**Rezoning Transportation Analysis**  
**Petition Number: Insert Zoning Petition #2021-060**  
*General Location Identifier: 09509220*

**Revision Log:**

Date	Description
05-27-2021	First Review (WB)
08-23-2021	Second Review (WB)

**RZ-1.0**

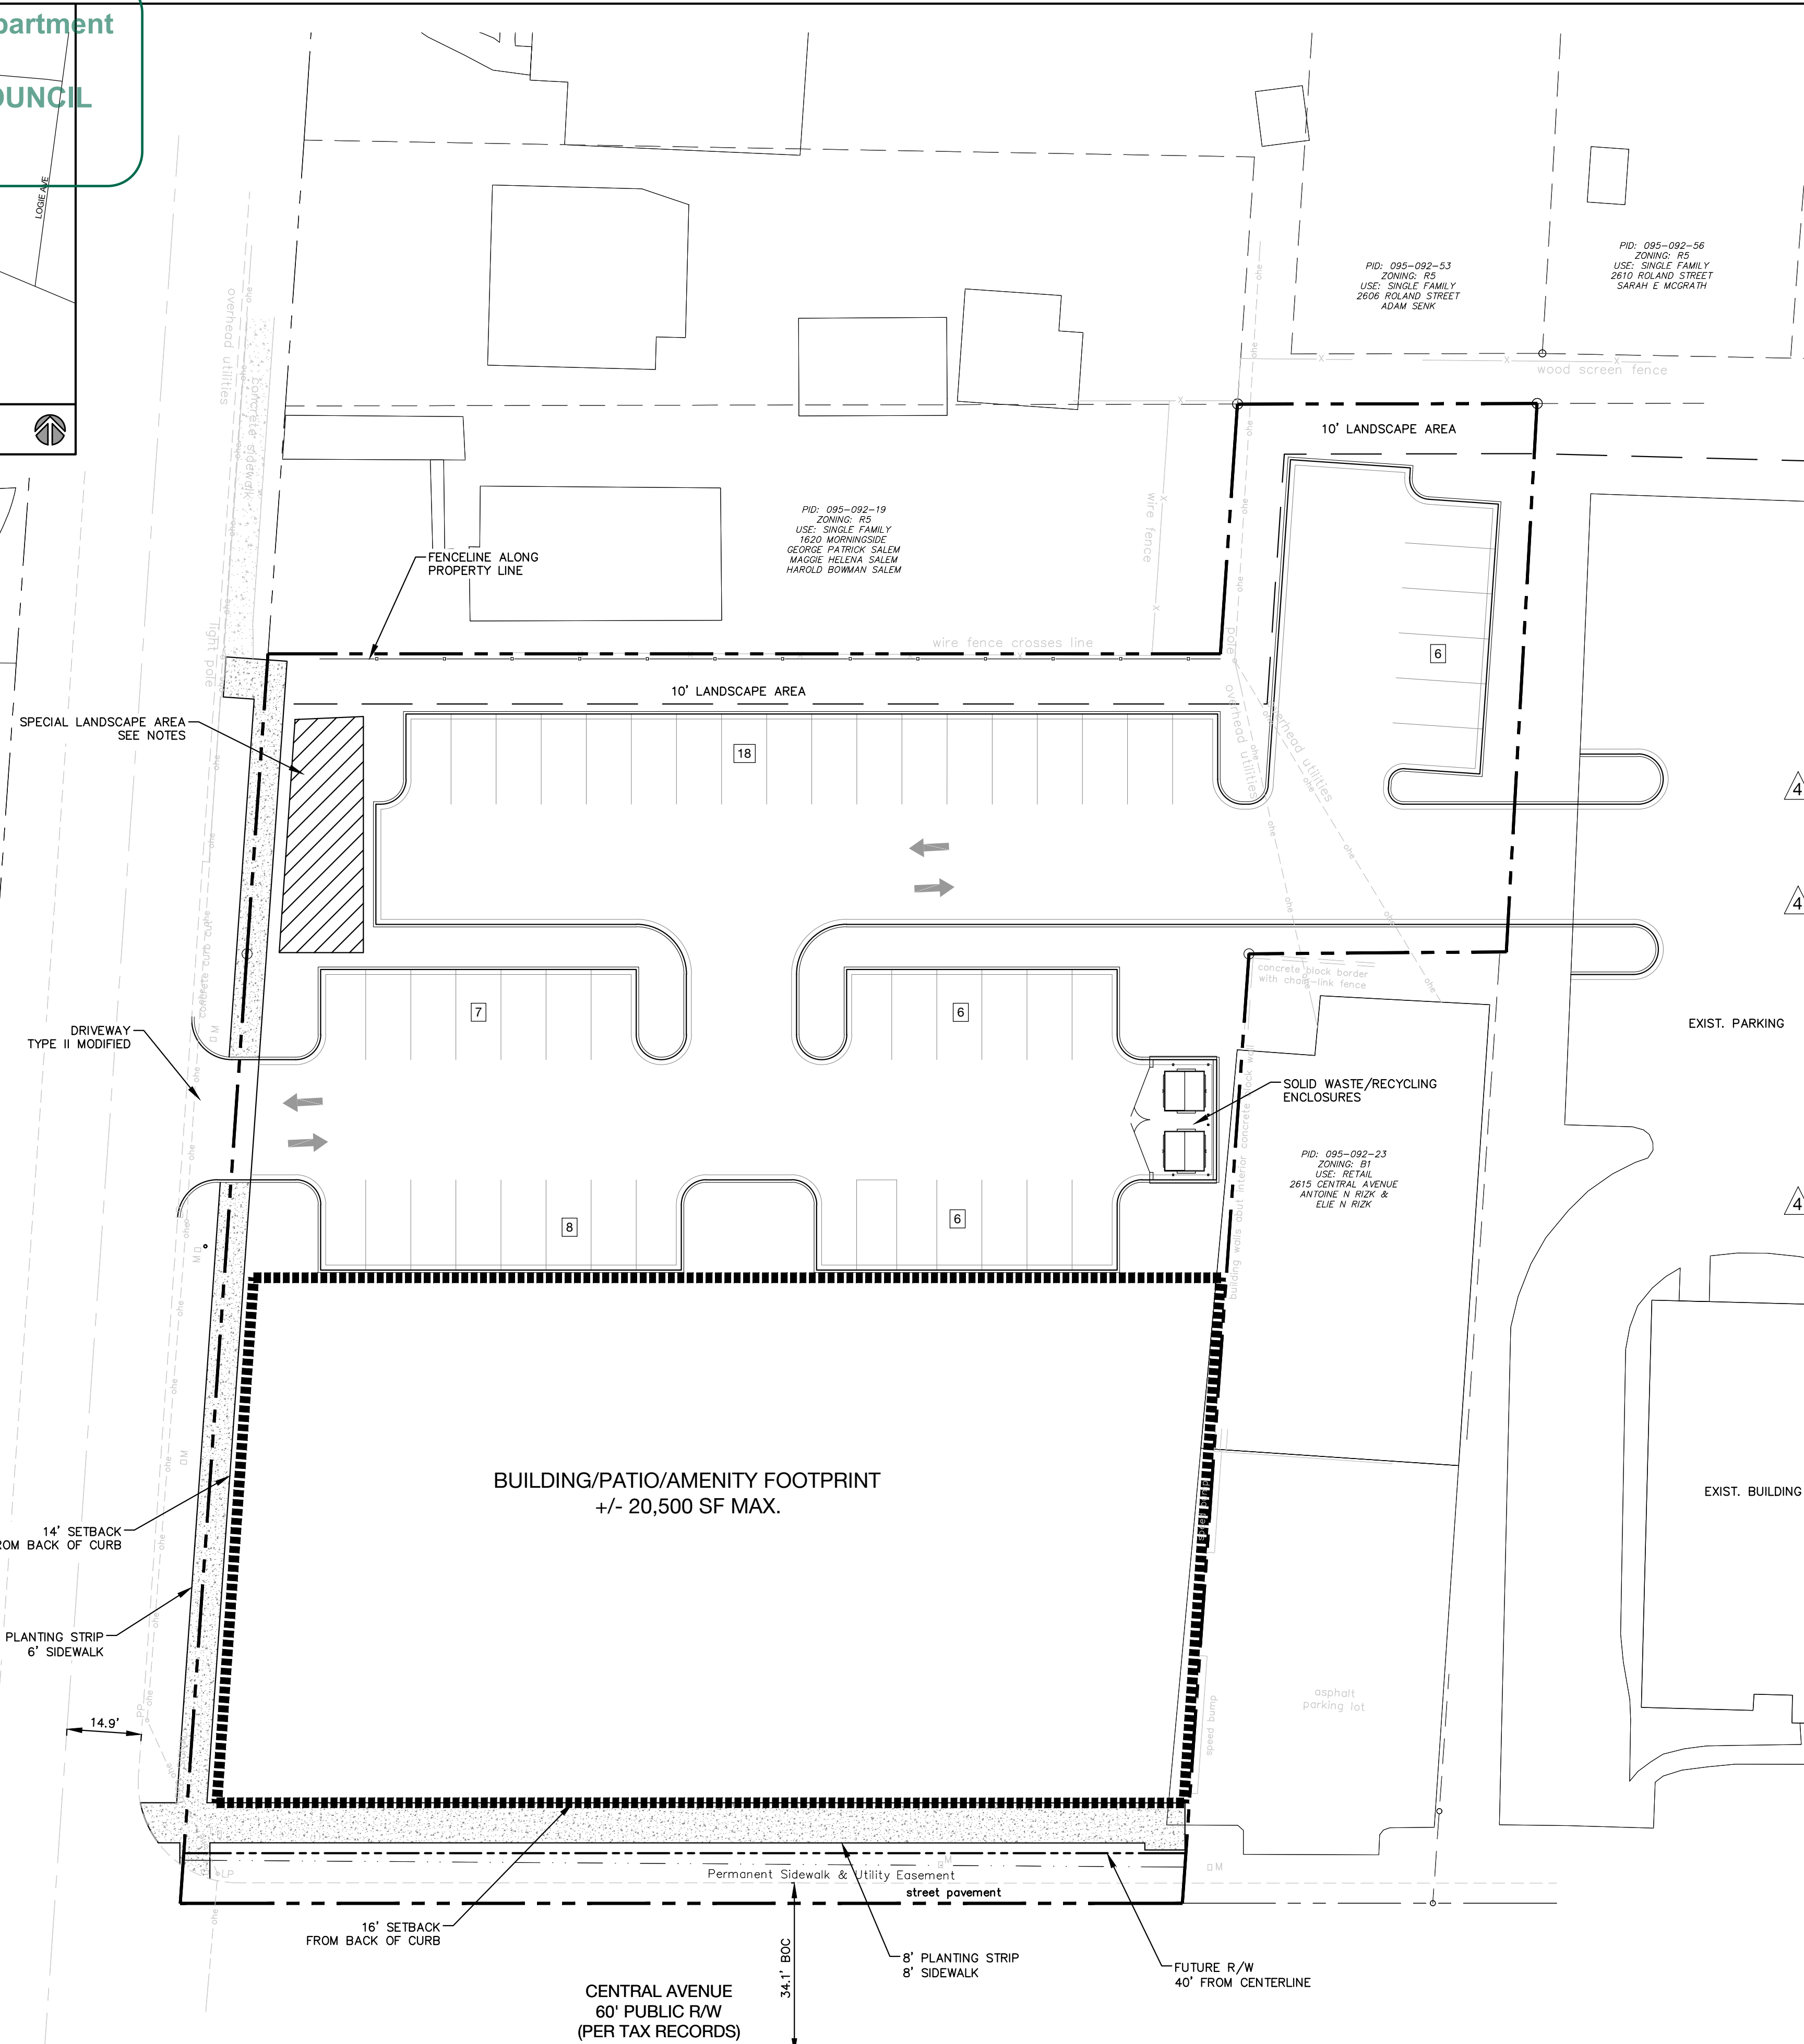
The site is located on Central Avenue, a City-maintained major thoroughfare and Morningside Drive, a City-maintained Local Road. The petitioner commits to installing two curb ramps at the Central Avenue and Morningside Drive Intersection per ADA law and PROWAG standards. The site plan also commits to providing a 6-foot sidewalk with an 8-foot planting strip along Morningside Drive and an 8-foot sidewalk with an 8-foot planting strip along Central Avenue. The wider sidewalk also meets the Charlotte WALKS Policy. Site plan revisions are needed to modify conditional note E. Further details are listed below.

1. ~~**Curbline:** The proposed zoning district has a setback measured from back of the existing or proposed future curbline.~~
  - a. ~~**Central Avenue:** The future location of curb and gutter is in its existing location.~~
  - b. ~~**Morningside Drive:** The future location of curb and gutter is in its existing location.~~

~~Label and dimension the curb and gutter from the centerline for each road on the site plan.~~
2. **Traffic Study:**  
A Traffic Impact Study (TIS) is not necessary for the complete review of this petition due to the site generating less than 2,500 daily trips. If during the permitting process the site generates more than 2,500 daily trips, then a traffic study will be required.
3. ~~Site plan and conditional note(s) revisions are needed to install two curb ramps at the Central Avenue and Morningside Drive Intersection per ADA law and PROWAG standards.~~
4. **REVISED COMMENT (08.23.2021)** Modify conditional note E, specifying dedication and fee simple conveyance of all rights-of-way to the City before the site's first building certificate of occupancy is issued is needed. ~~CDOT requests rights of way set at 2' behind back of sidewalk where feasible.~~
